TELOPEA STAGE 1A

DPE RFI RESPONSE

13/12/2023

DPE RFI 6 NOVEMBER COMMENT

BASEMENT 02
SCALE: 1:500@A1

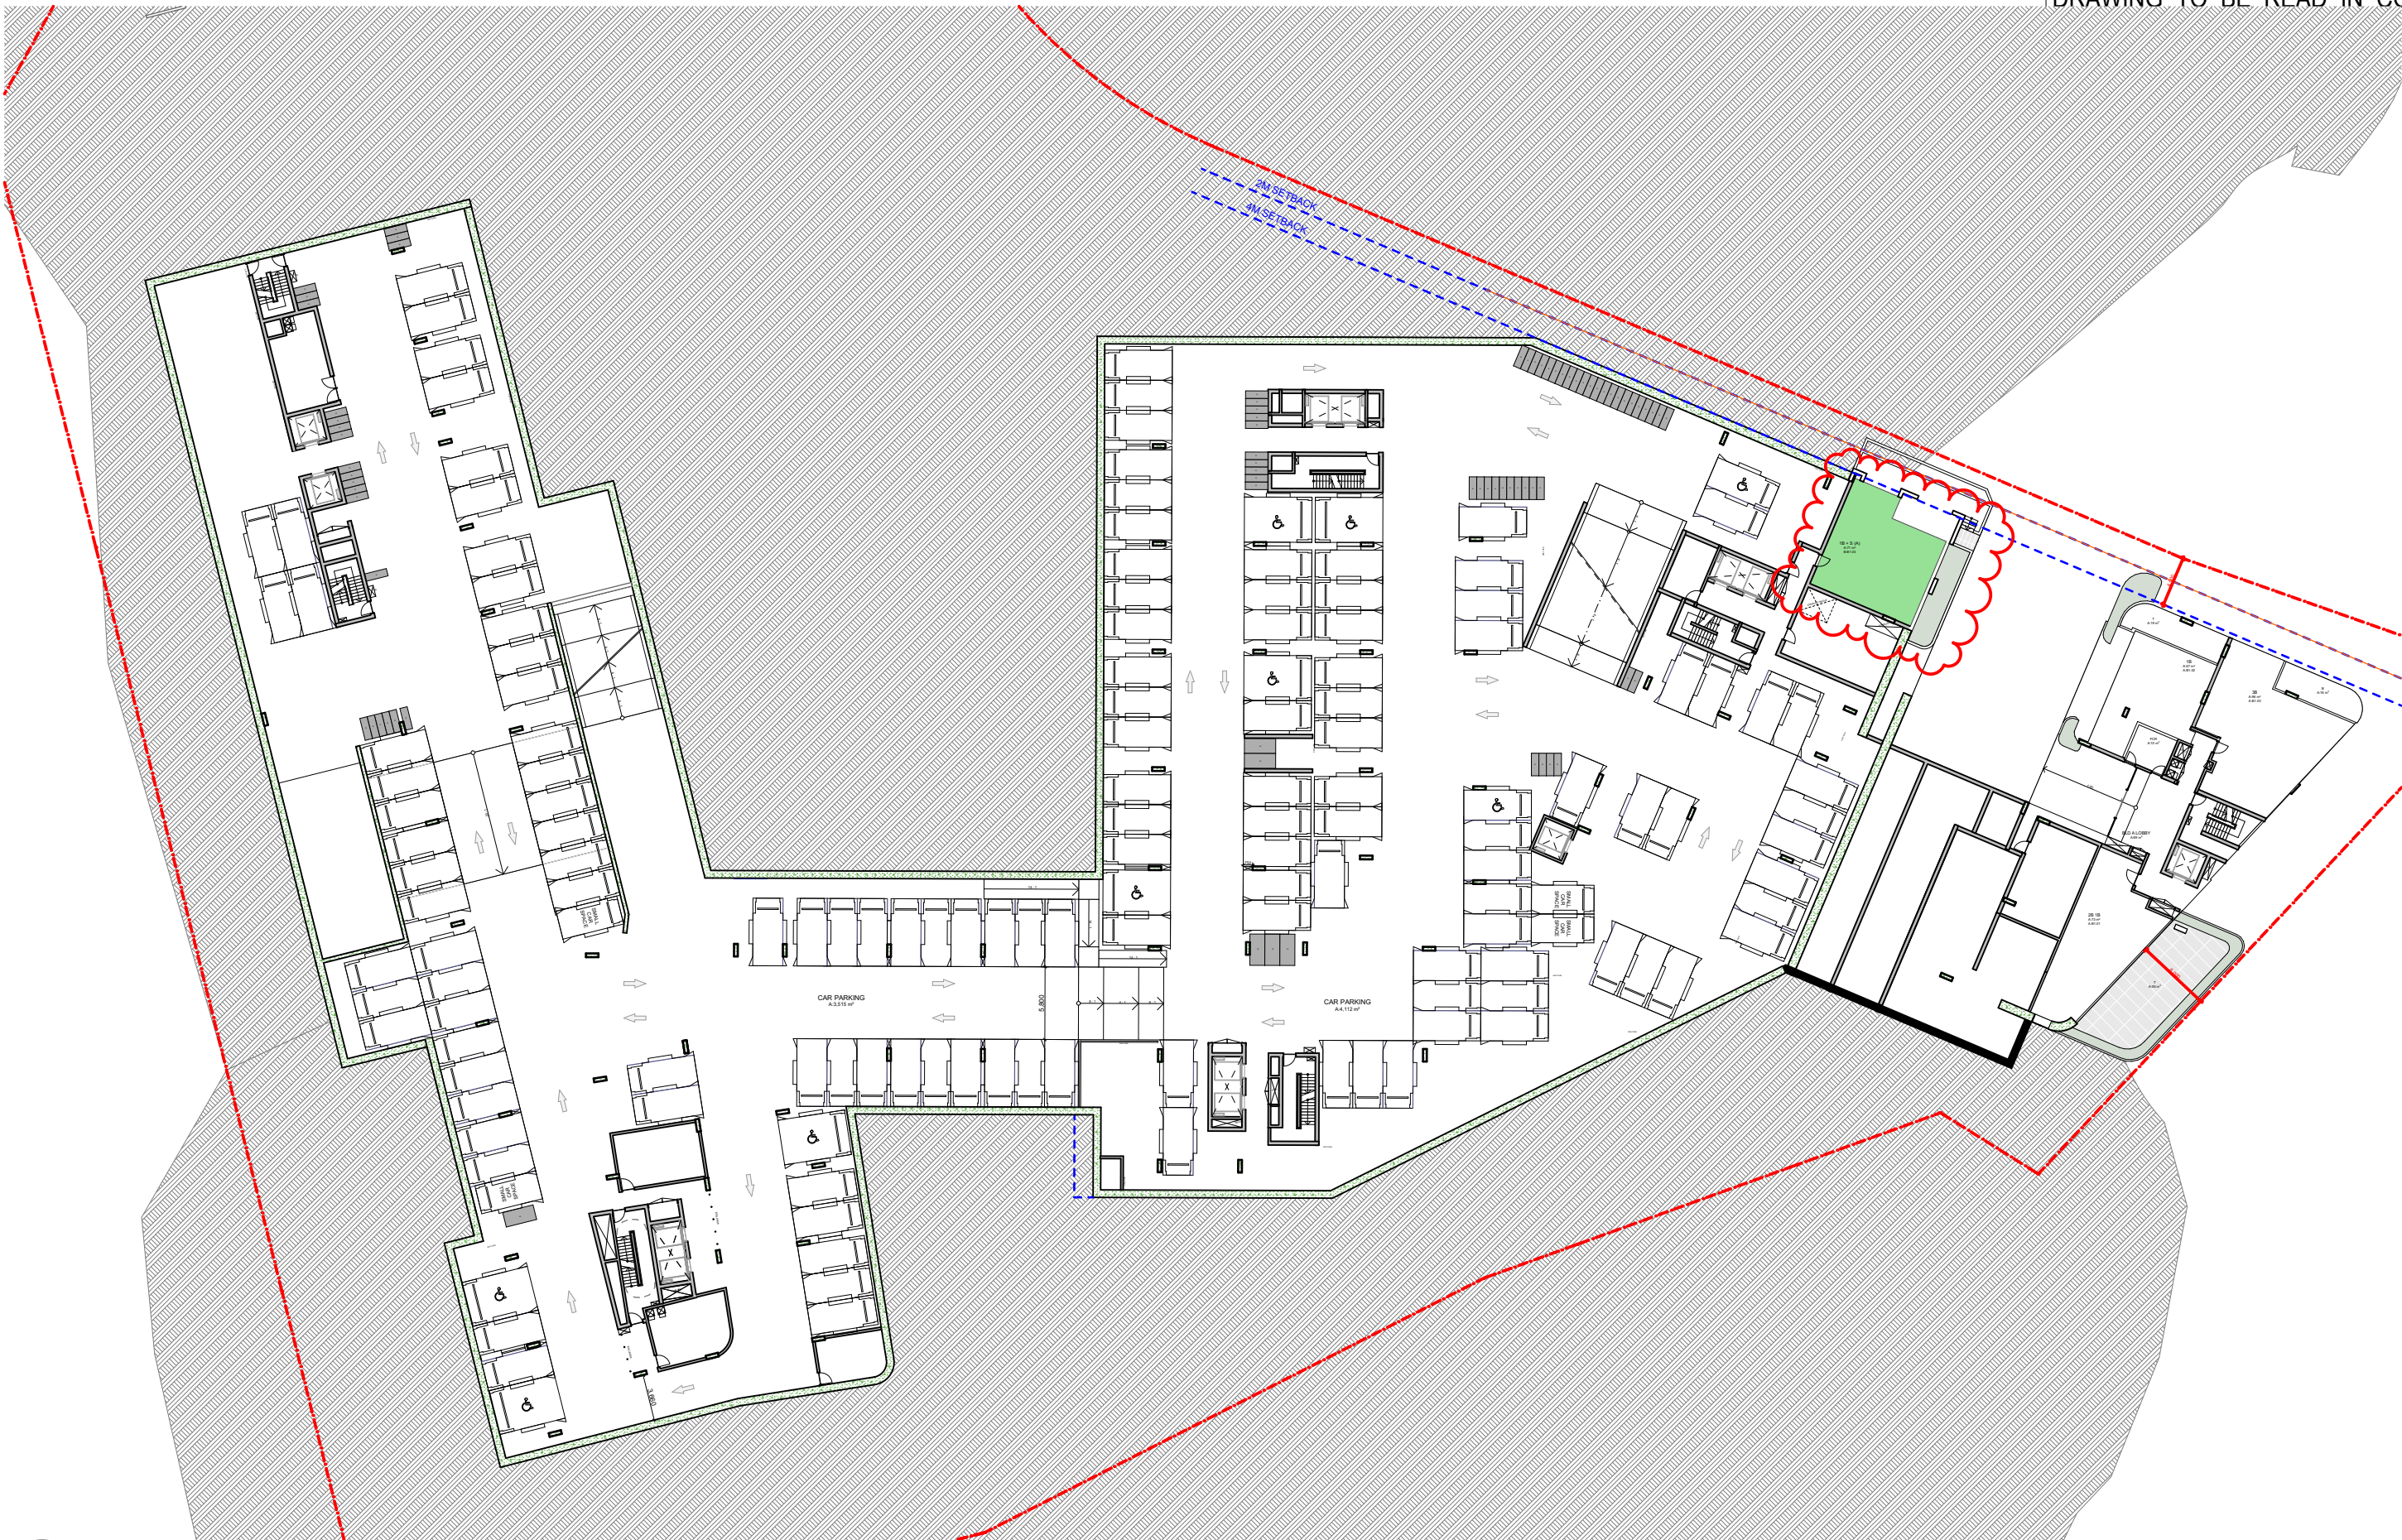
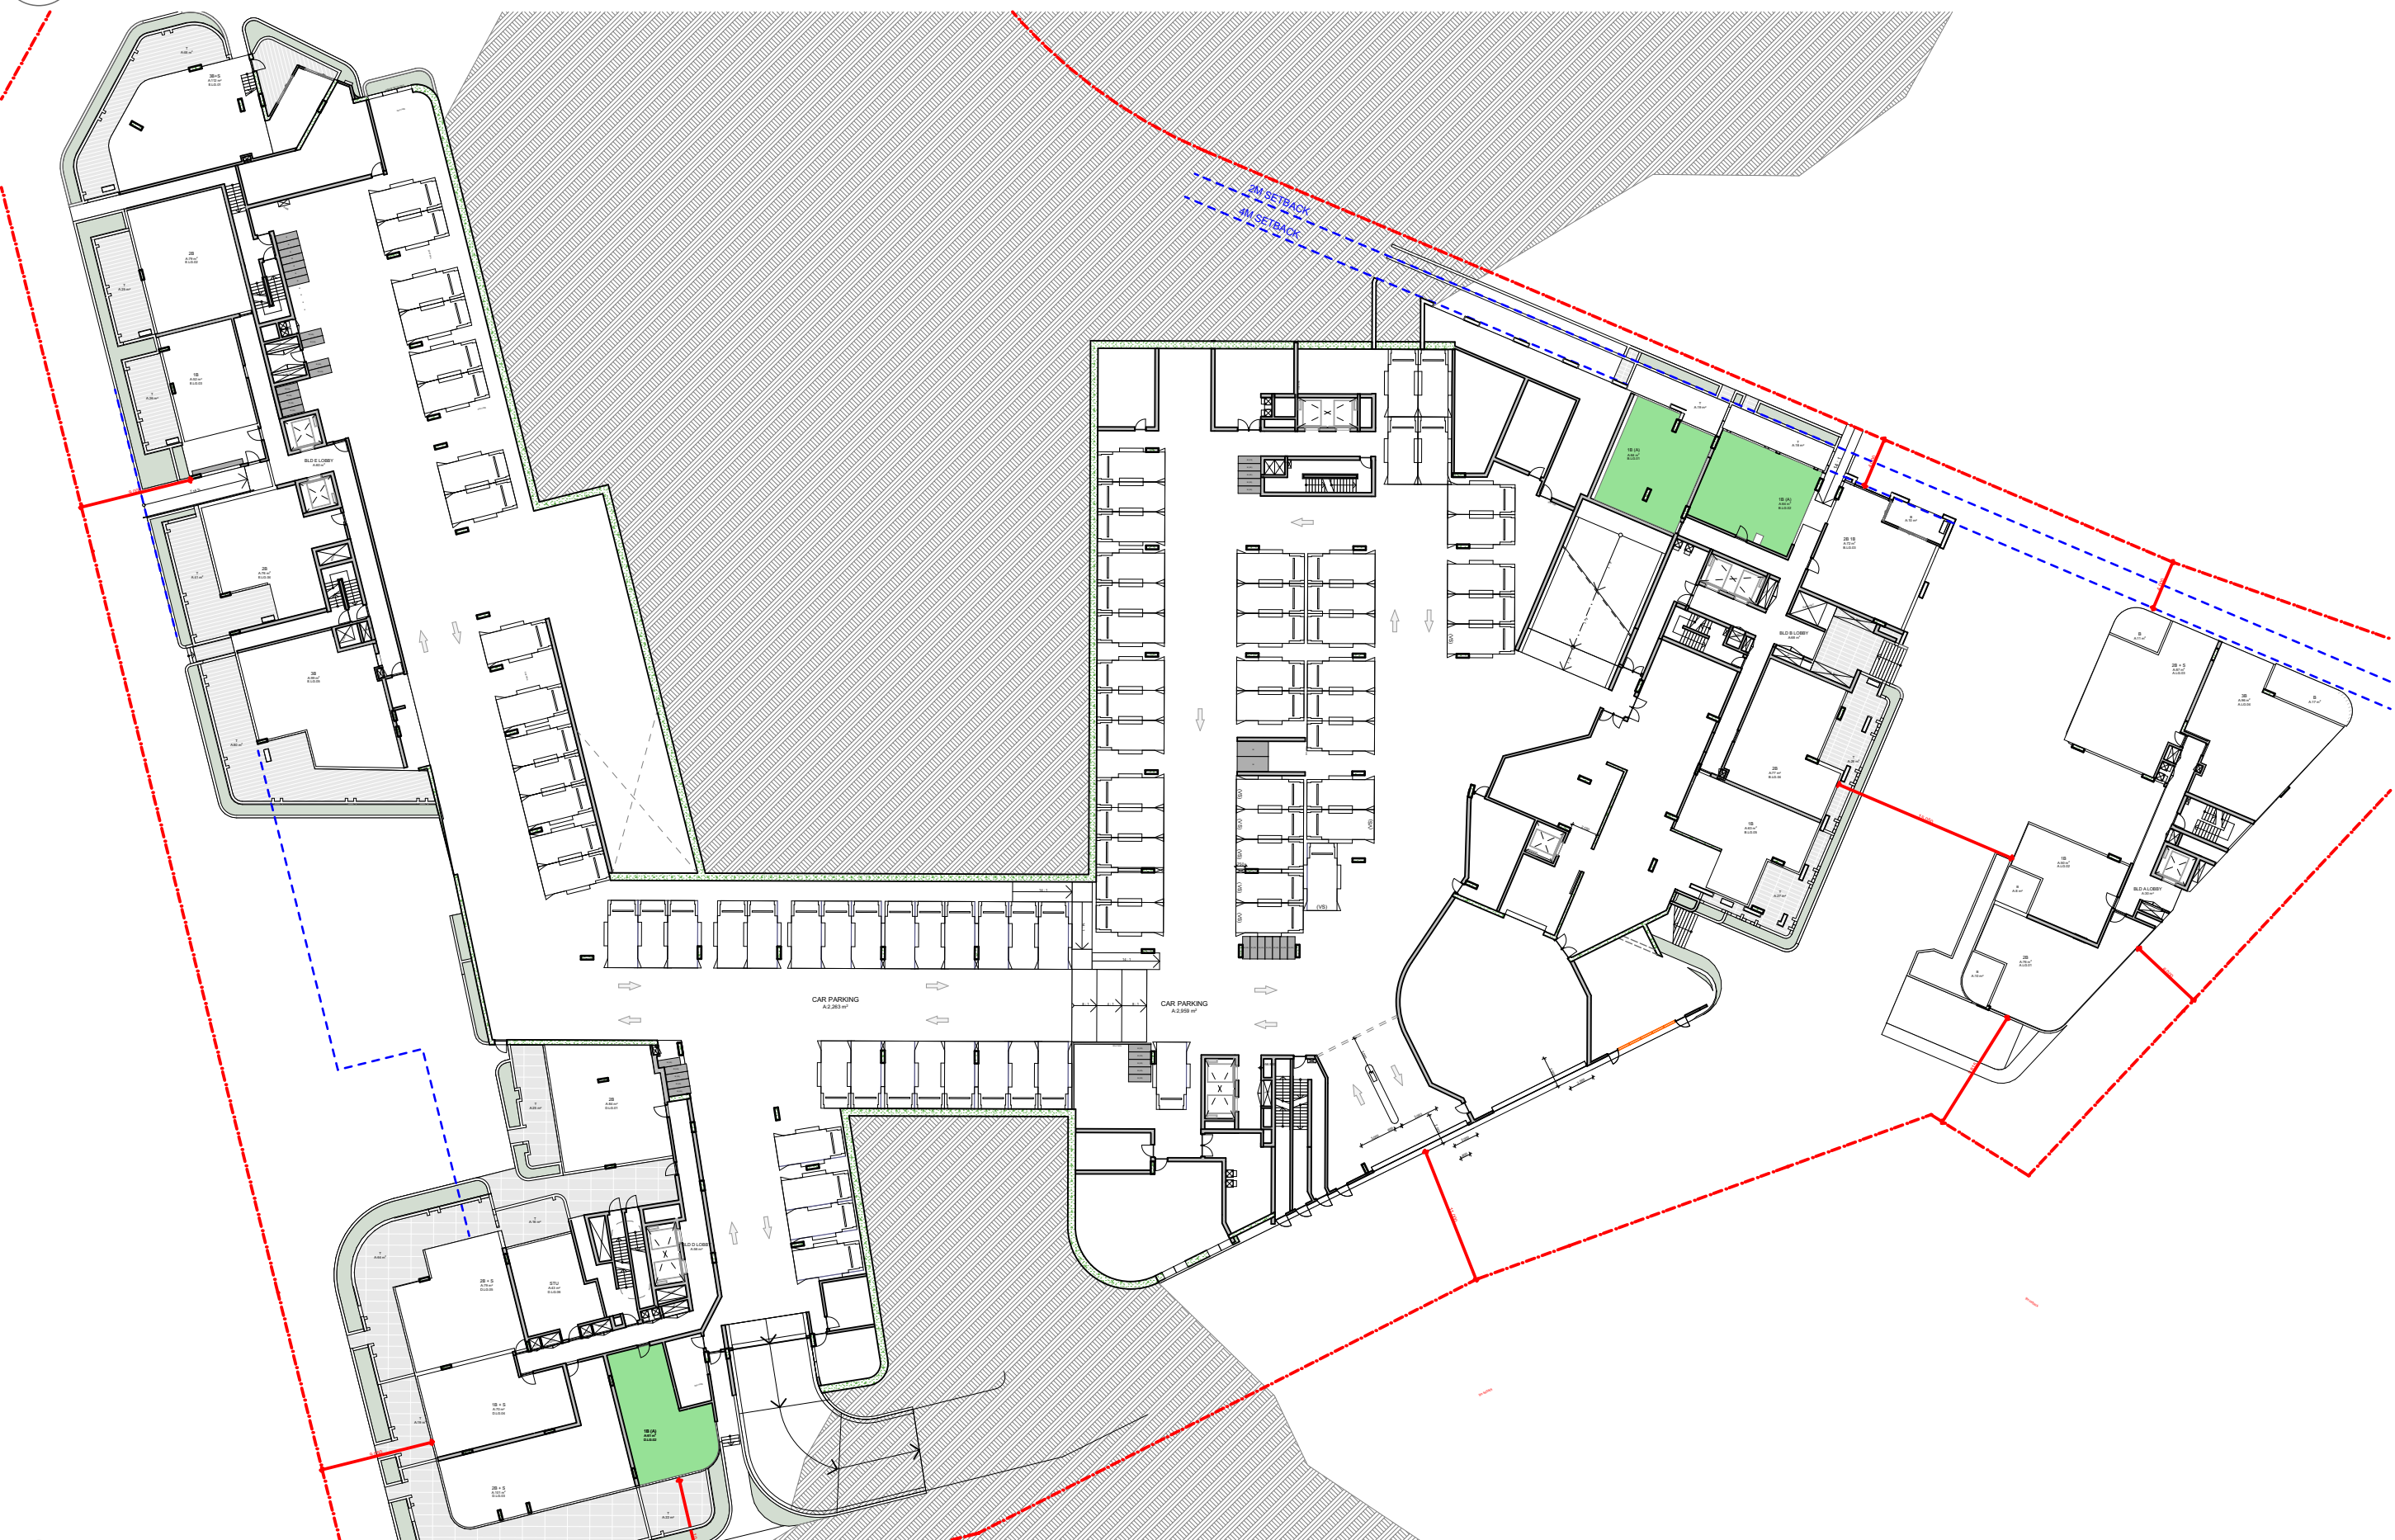
2.1.b.
The Department raises concerns about the proposed Building A and B basements projecting above the finished ground level along Sturt Street as it would result in large blank walls to the street. Amend the buildings’ design to ensure it achieves an appropriately designed interface to the street.

Amendments to Buildings A and B aim to reduce blank walls to the Sturt Street frontage and reflect Council's request for a minimum setback of 4 metres to be free of basement structure in order to establish thriving trees and landscaping. Specifically, to the Architectural Plans include:

Basement 02:
Relocation of 10 car spaces and storage spaces to provide a 4 metre setback along Sturt Street

Introduction on 1 x one bedroom apartment in Building A

Basement 01:
Relocation of 5 car spaces and storage spaces to provide a 4 metre setback along Sturt Street

Introduction on 1 x one bedroom apartment in Building B

Lower Ground:
Reconfiguration of B.LG.01, B.LG.02 and B.LG.03 to provide terraced landscaping
